PLATTE SELF STORAGE

GRADING AND EROSION CONTROL PLAN

AUGUST 2024

OVERVIEW SHEET

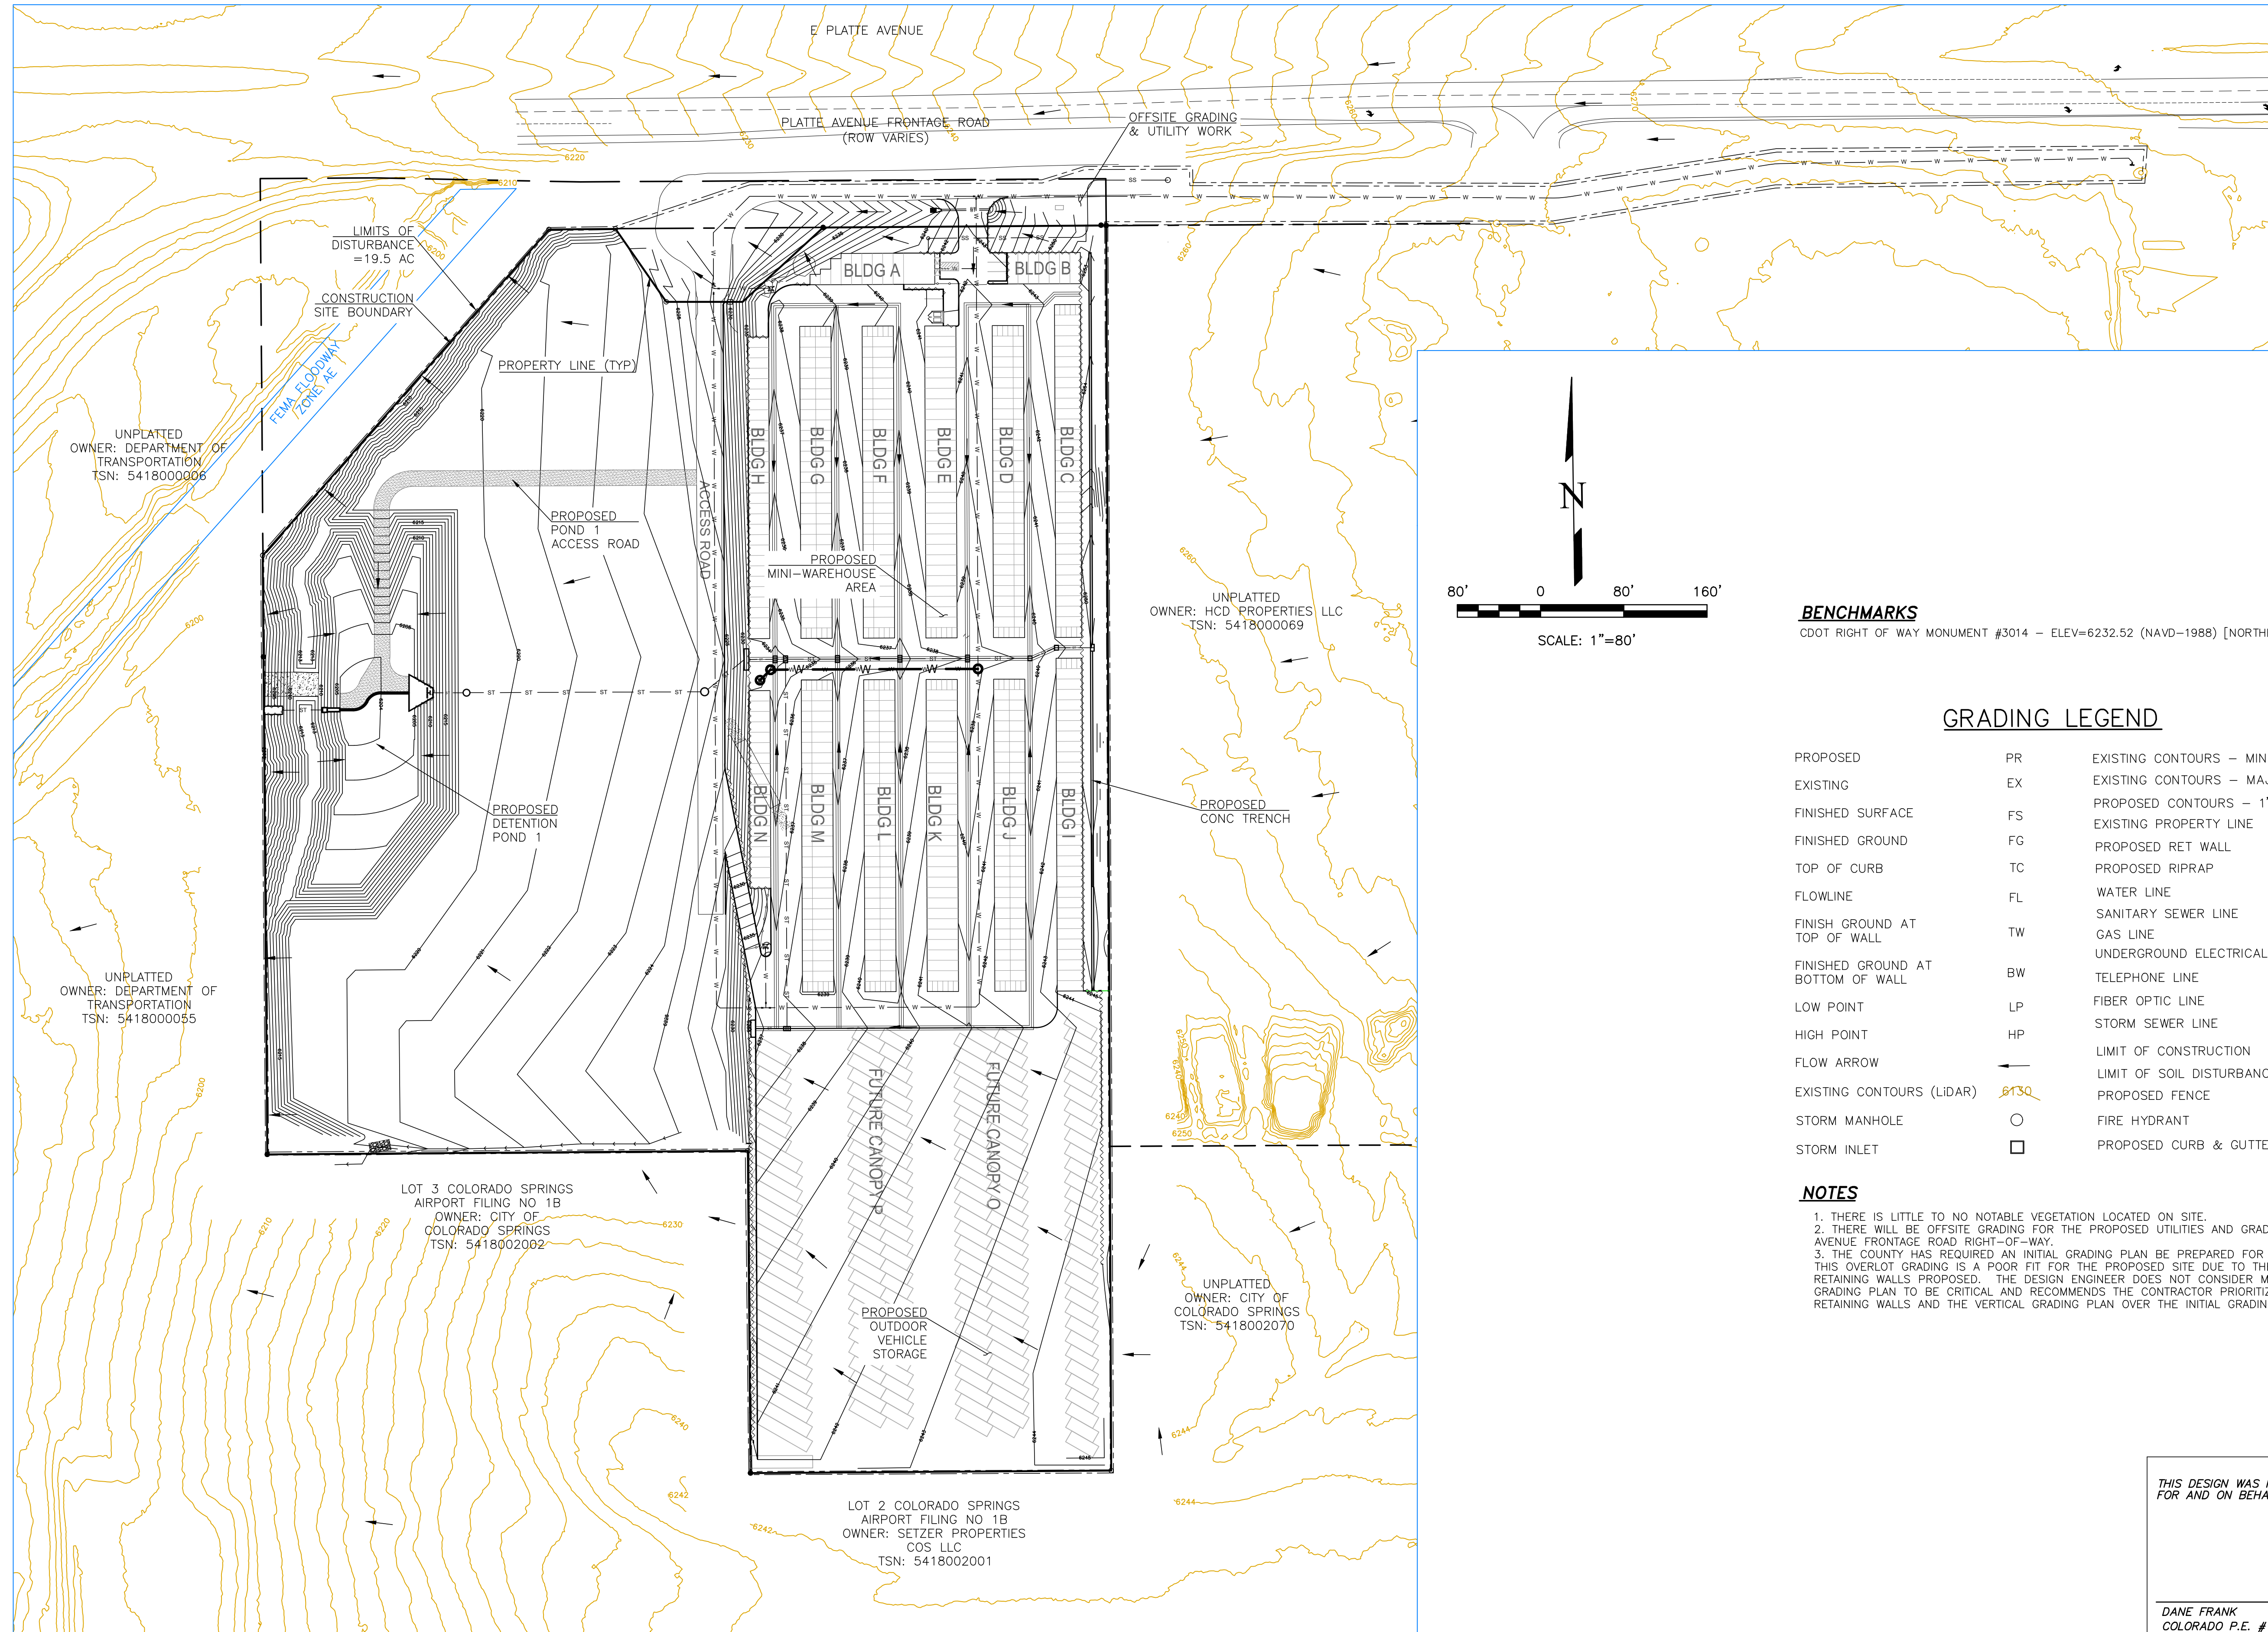
Unresolved from Submittal 1: The comment response stated that the applicant will need to grade the entire lot. Please update or remove this note. The County is not requiring overlot grading for the entire site, if the applicant wants to that is fine but this note reads as if the County is requiring overlot grading.

Overlot grading will not be required and if only a portion of the lot is proposed to be developed it is not recommended to disturb more soil than necessary. With the grading and erosion control plans you do need initial, interim, and final control measures shown but the initial does not need to be for the entire overlot area if the applicant/engineer does not prefer that. Please clarify this statement. Typical comment for all sheets with this note.

INITIAL GRADING & EROSION CONTROL - NORTH SIDE

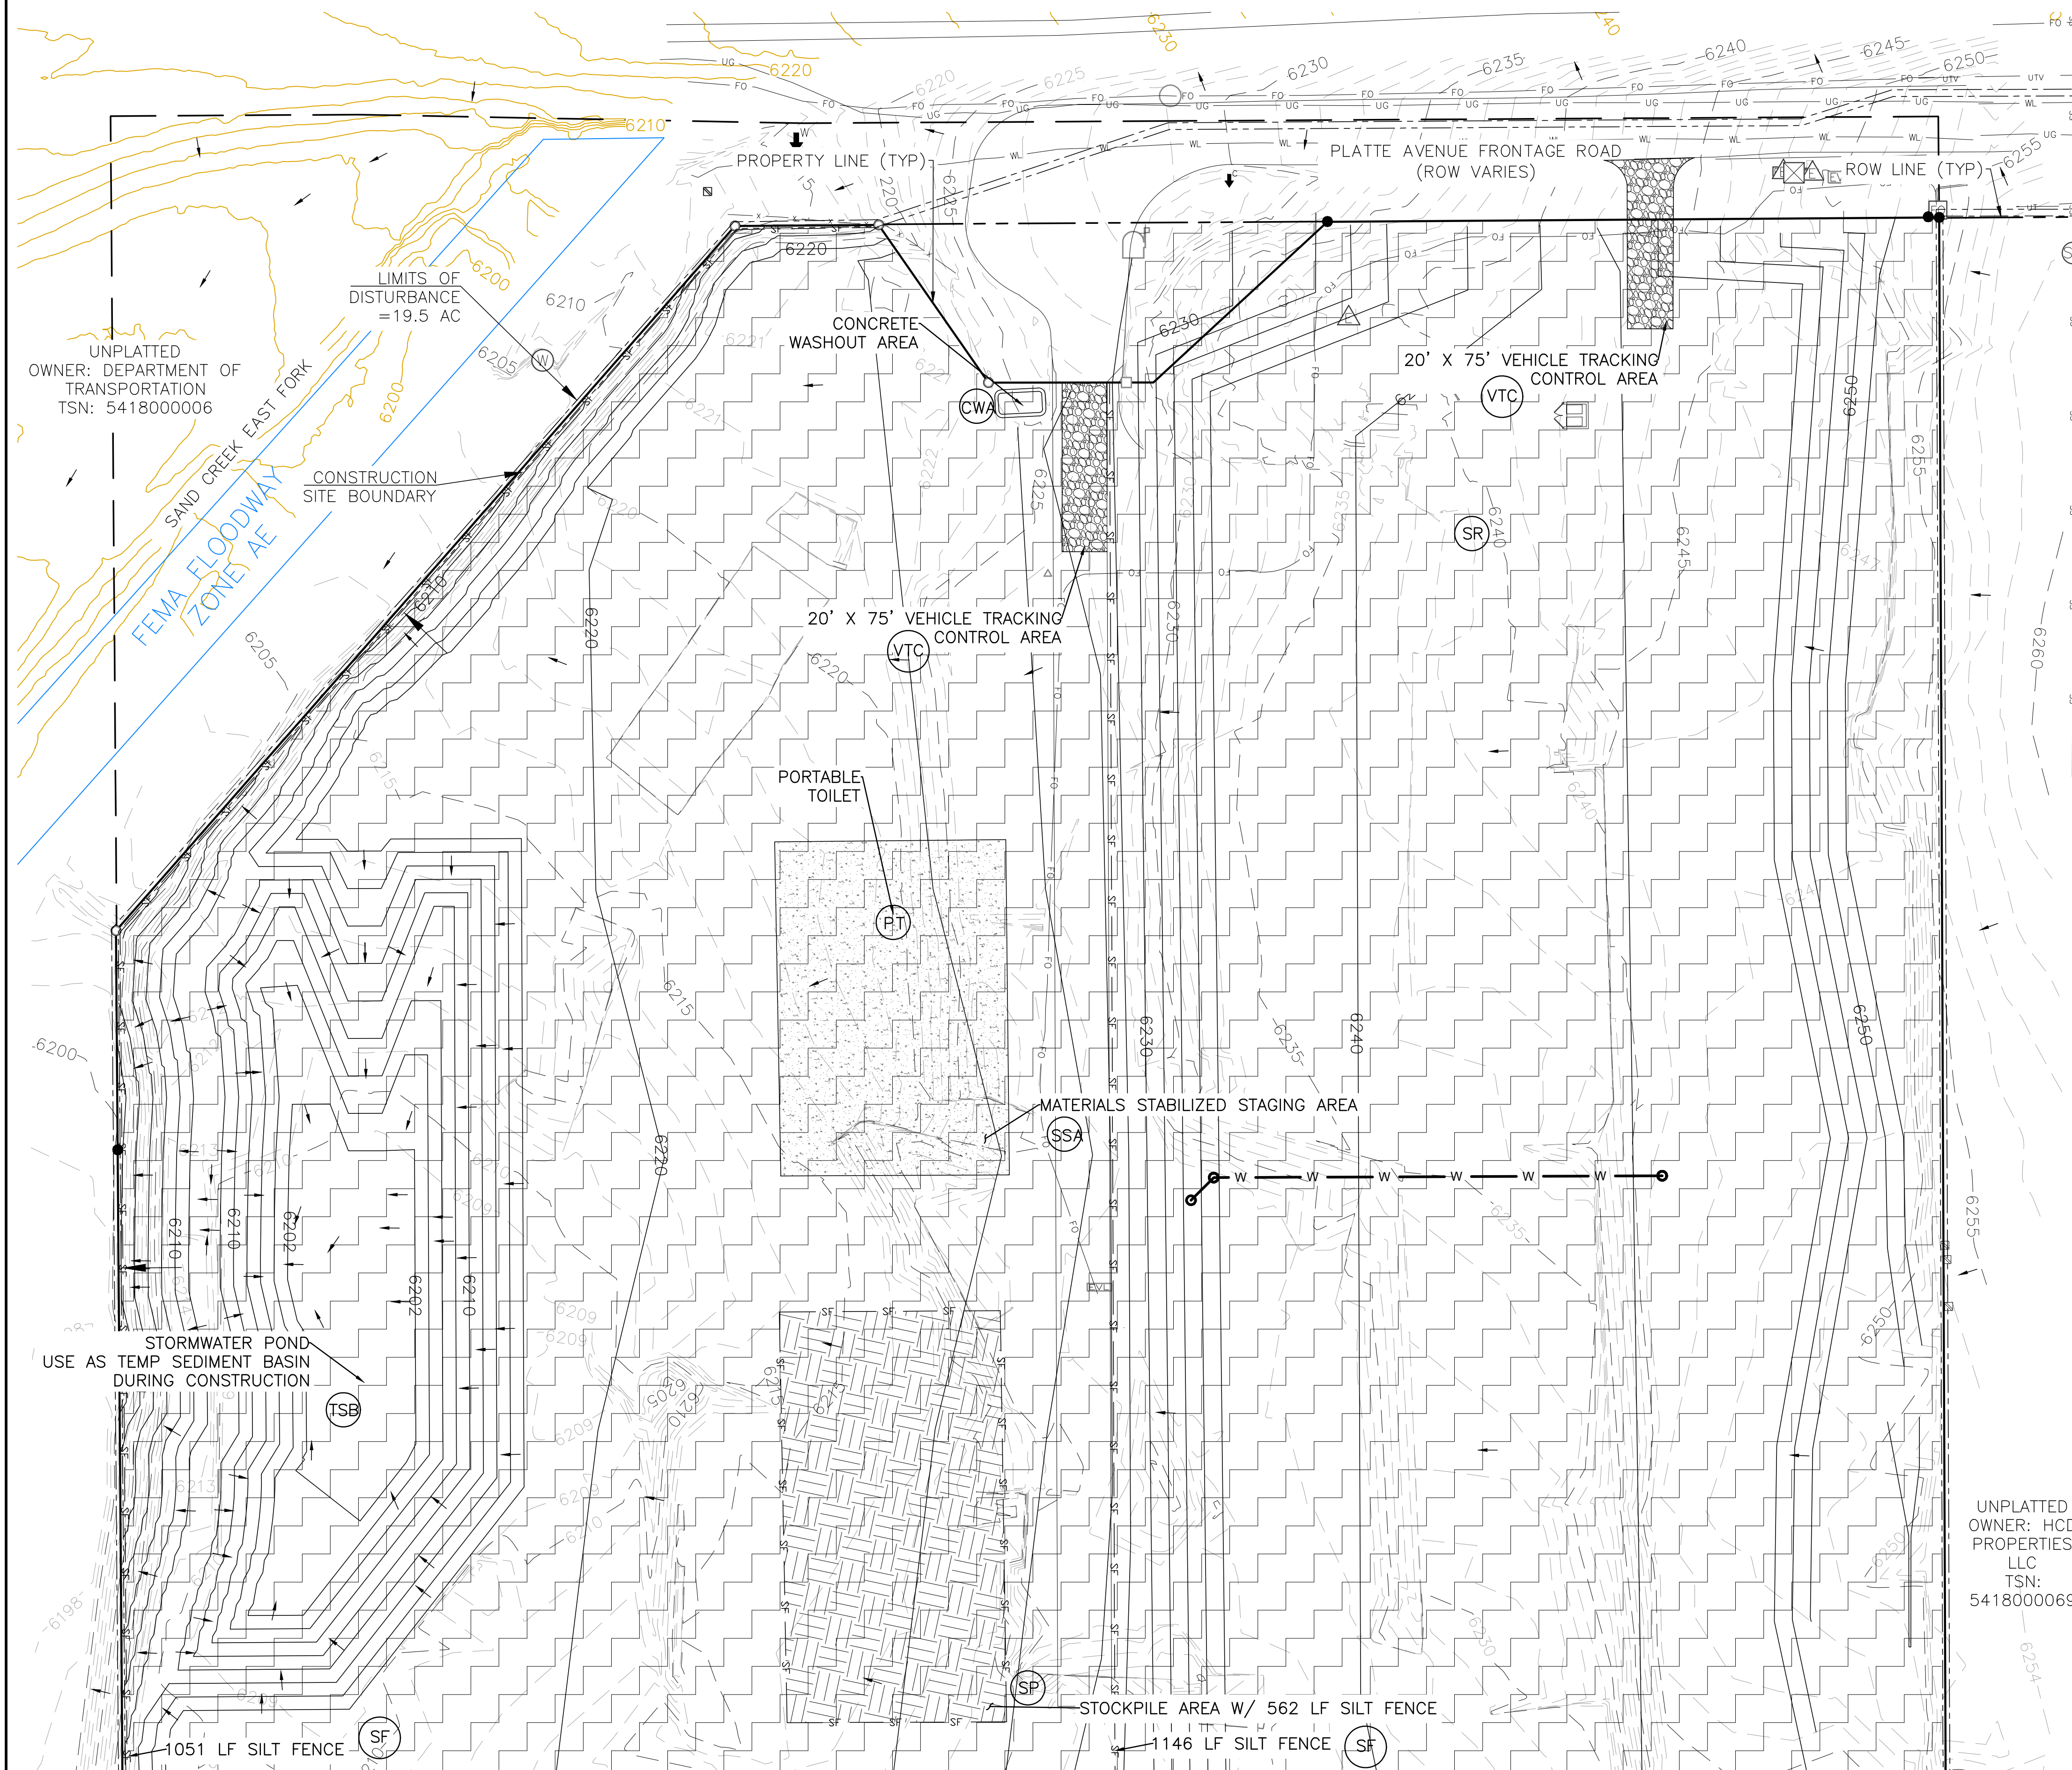
Please include full limits of construction within the view, it appears to extend further to the east.

INTERIM EC PLAN - NORTH SIDE

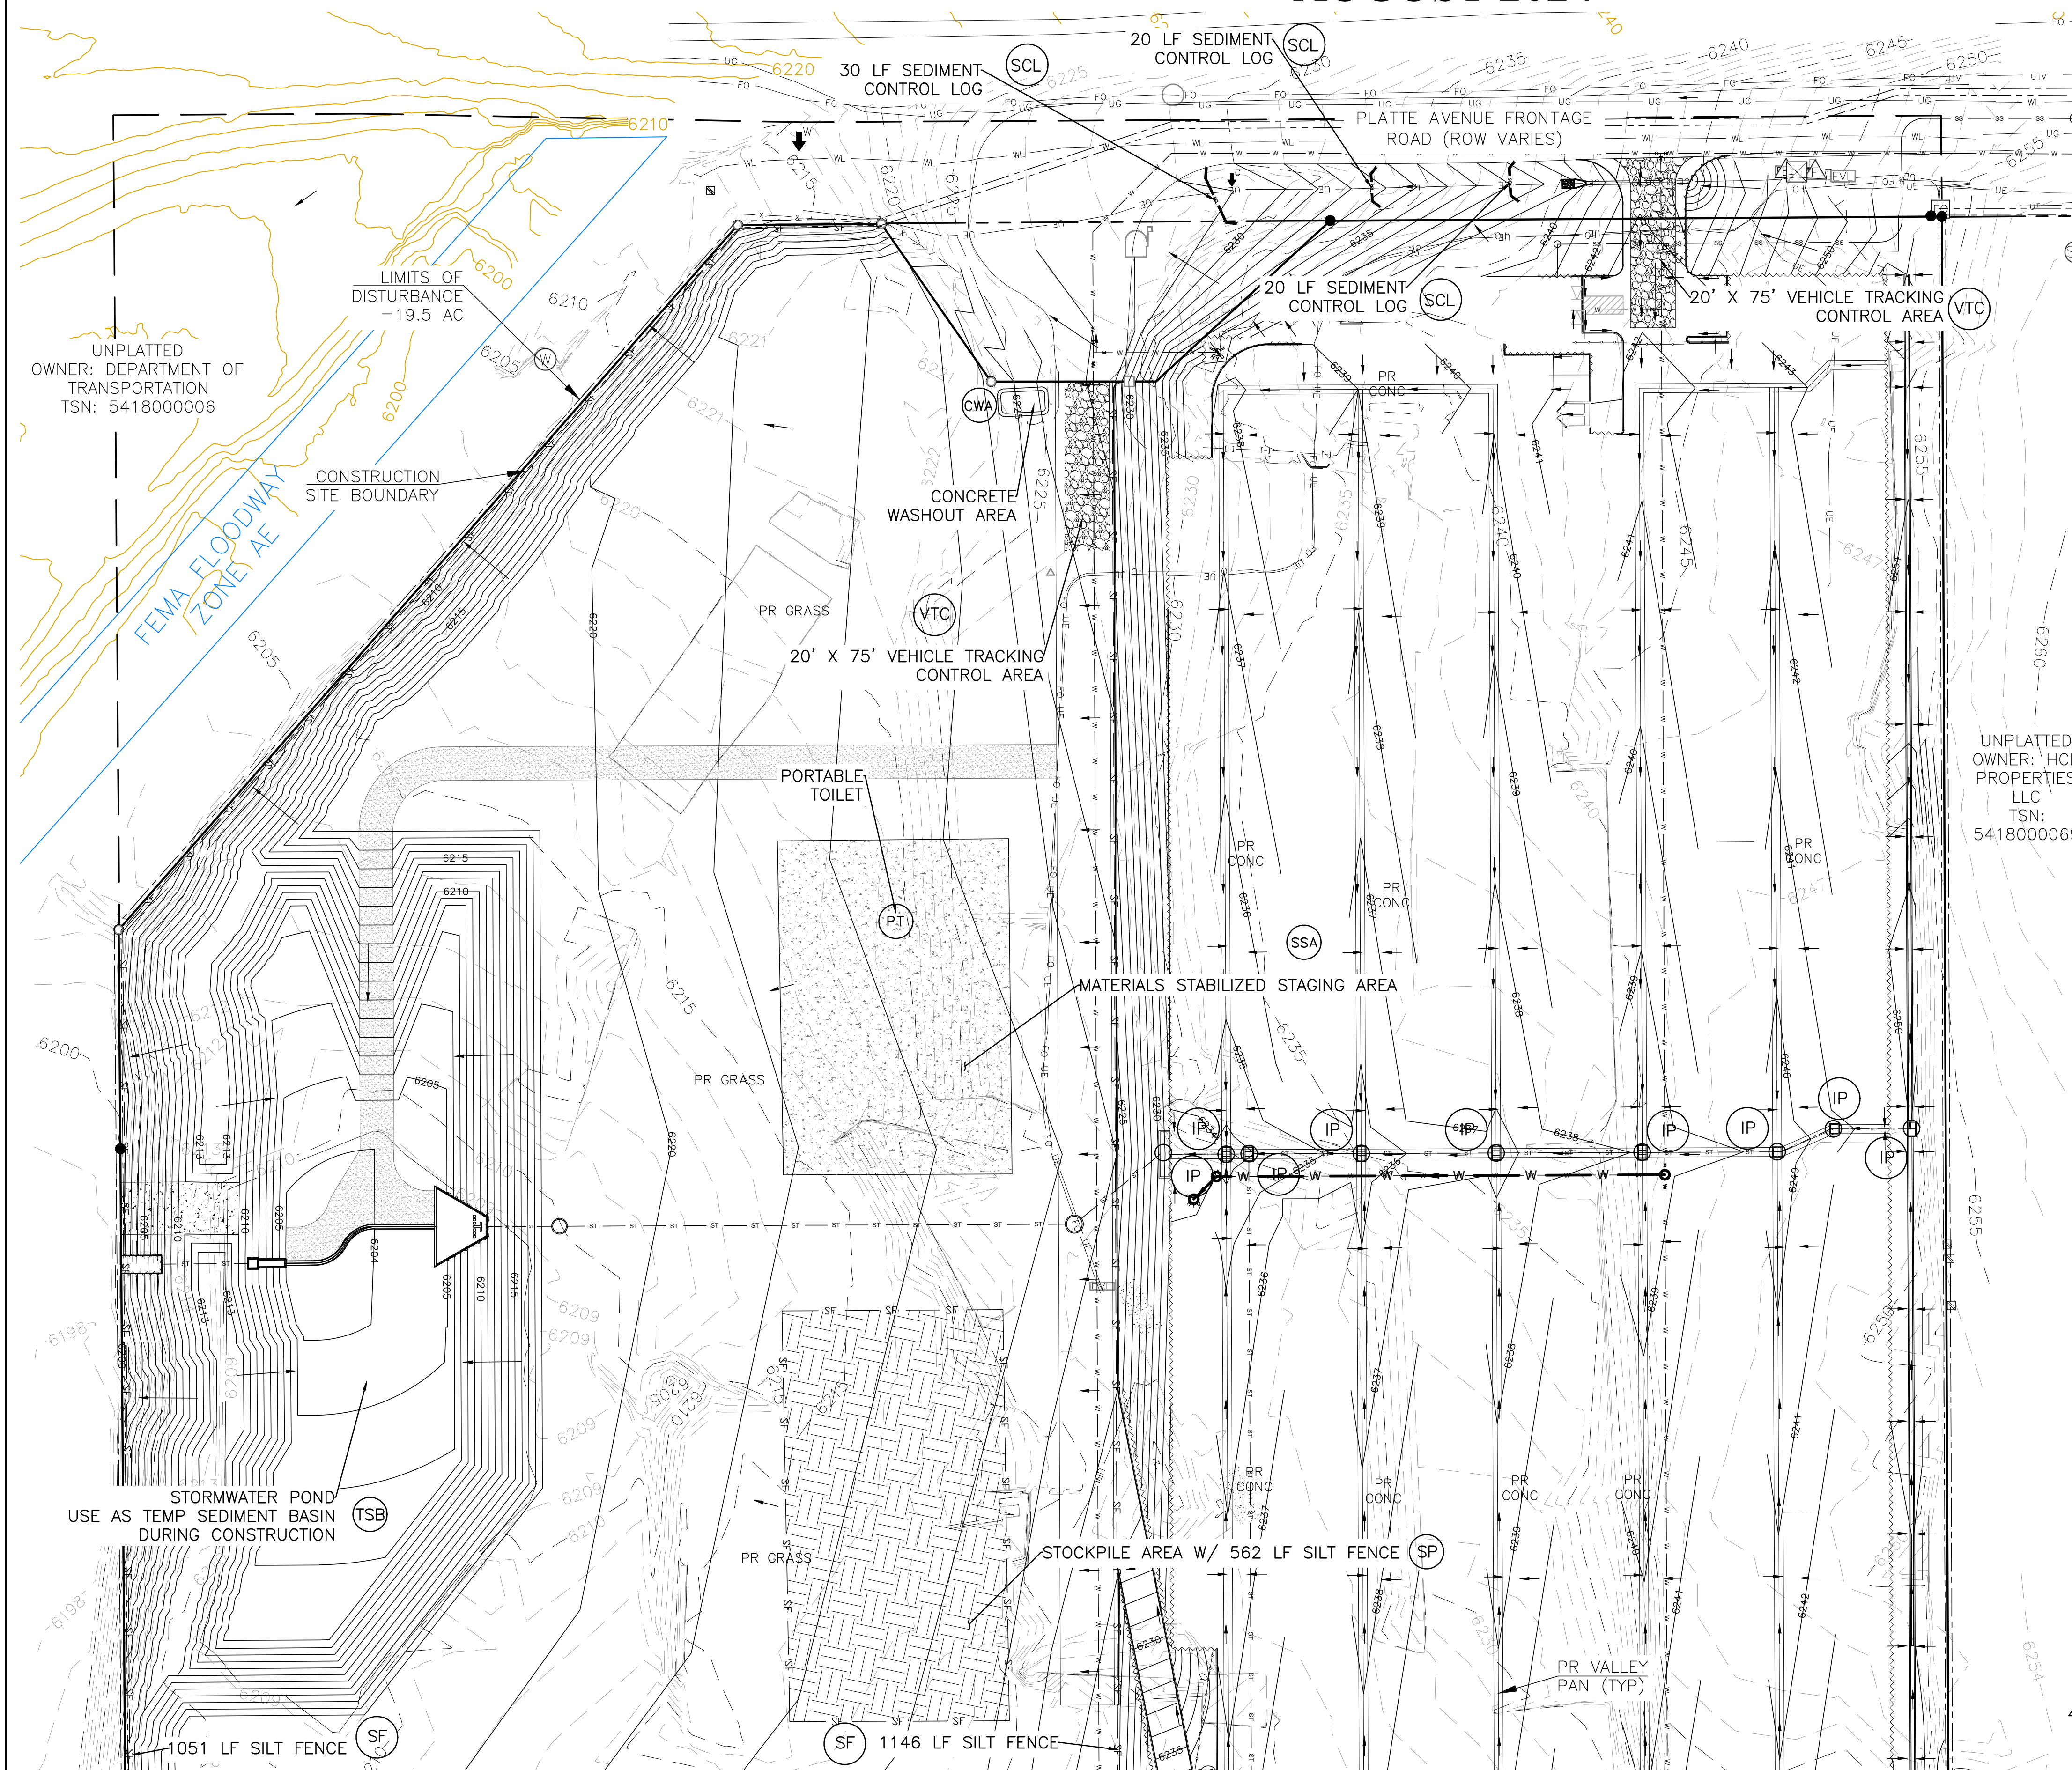
Unresolved:
Show cut/fill limits
